Site Development Letter of Intent

PCD File NO: PPR2425

This request is to add a commercial building 175x50 using pole barn construction to the existing parcel. The existing parcel is approximately 8.07 acres of vacant industrial storage.

Landscape Plan

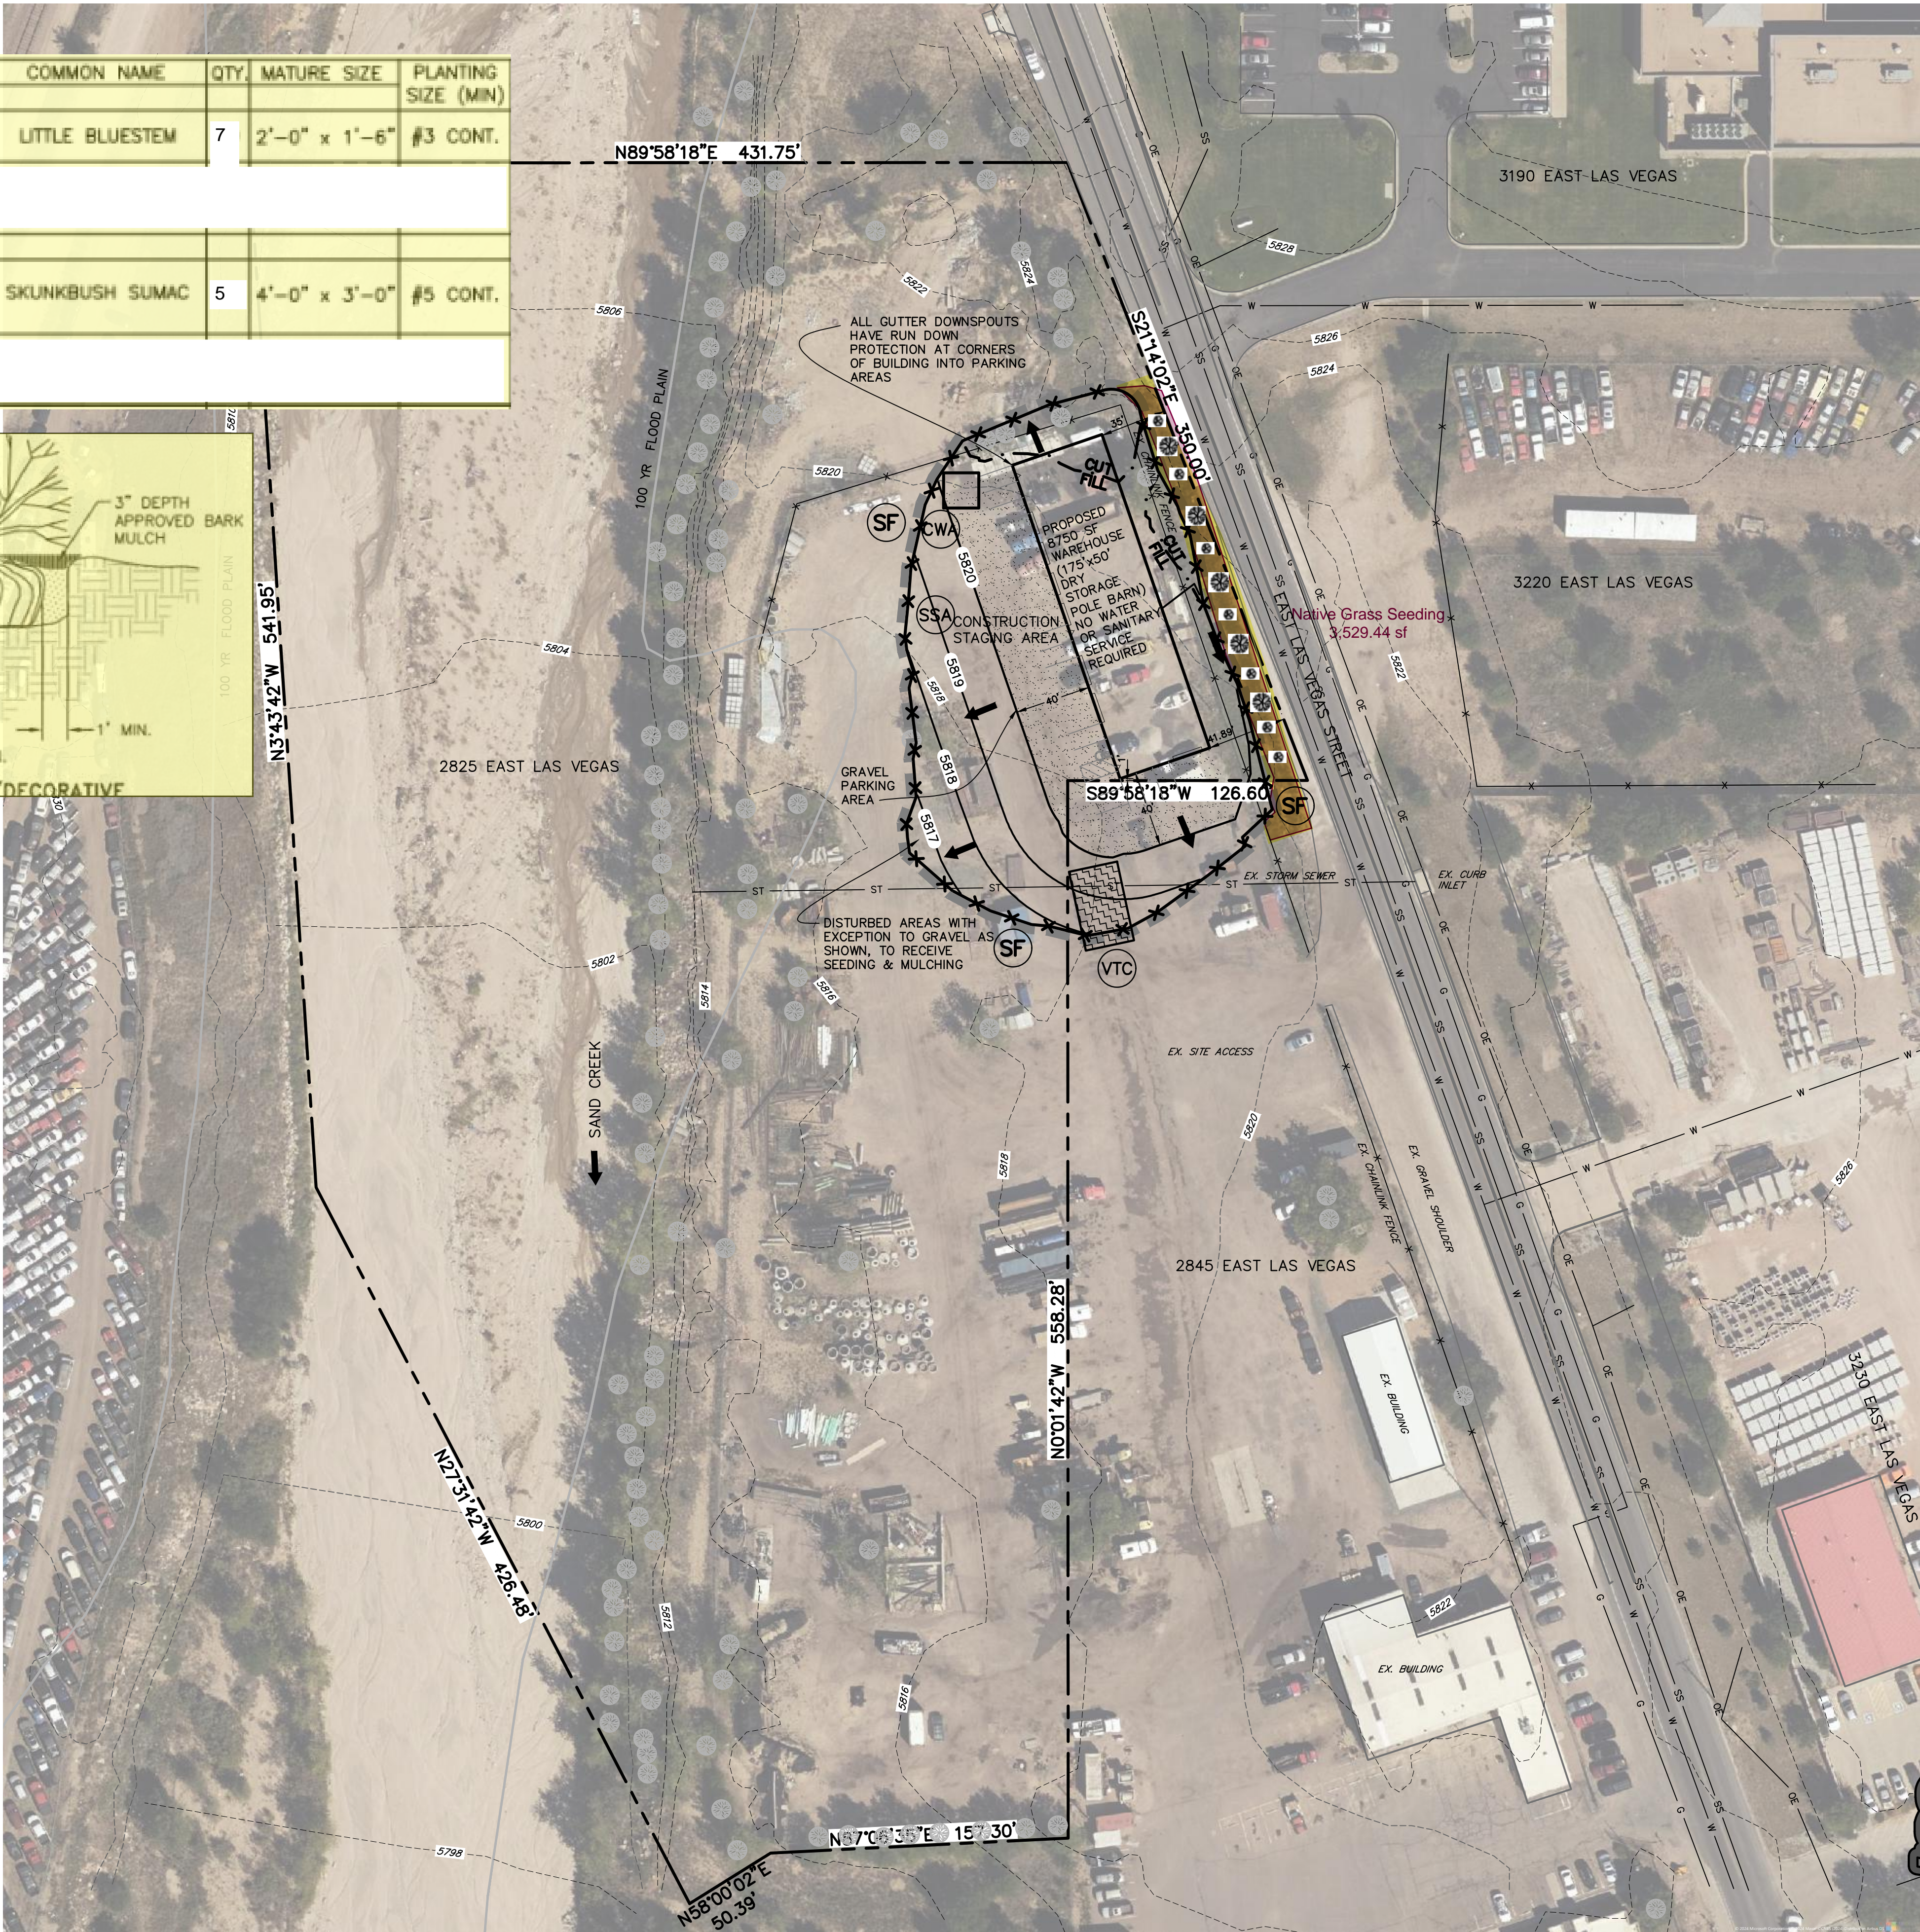
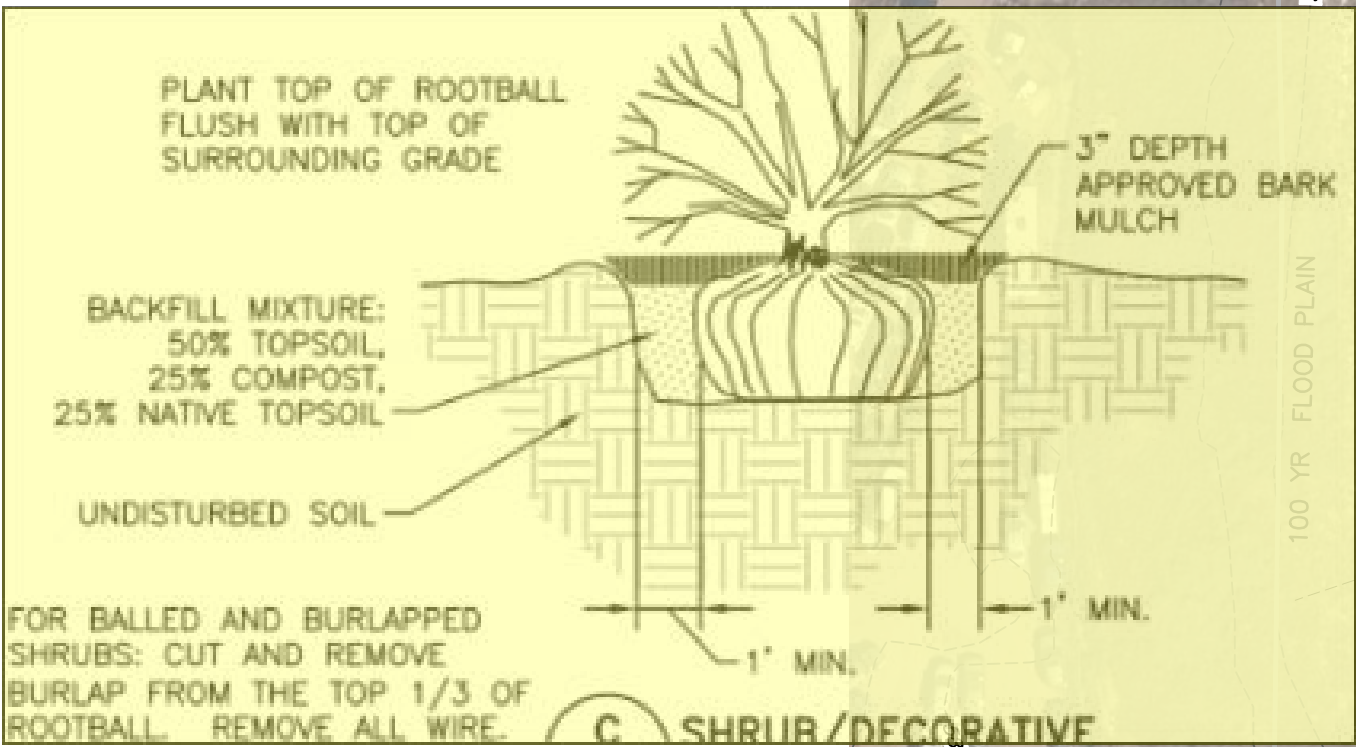
Please add:  
request for a  
director approved  
substitute  
landscape design.

No changes in use or operation have taken place. Property is an additional parcel to an existing property of the same owners and is utilized as work, equipment and trailer storage. There are no existing buildings on this parcel. This will be the first structure on this parcel. This parcel follows all requirements of the Land Development code and zoning of the parcel. This parcel has no water service, and will not so we will need a director approved substitute landscape design.
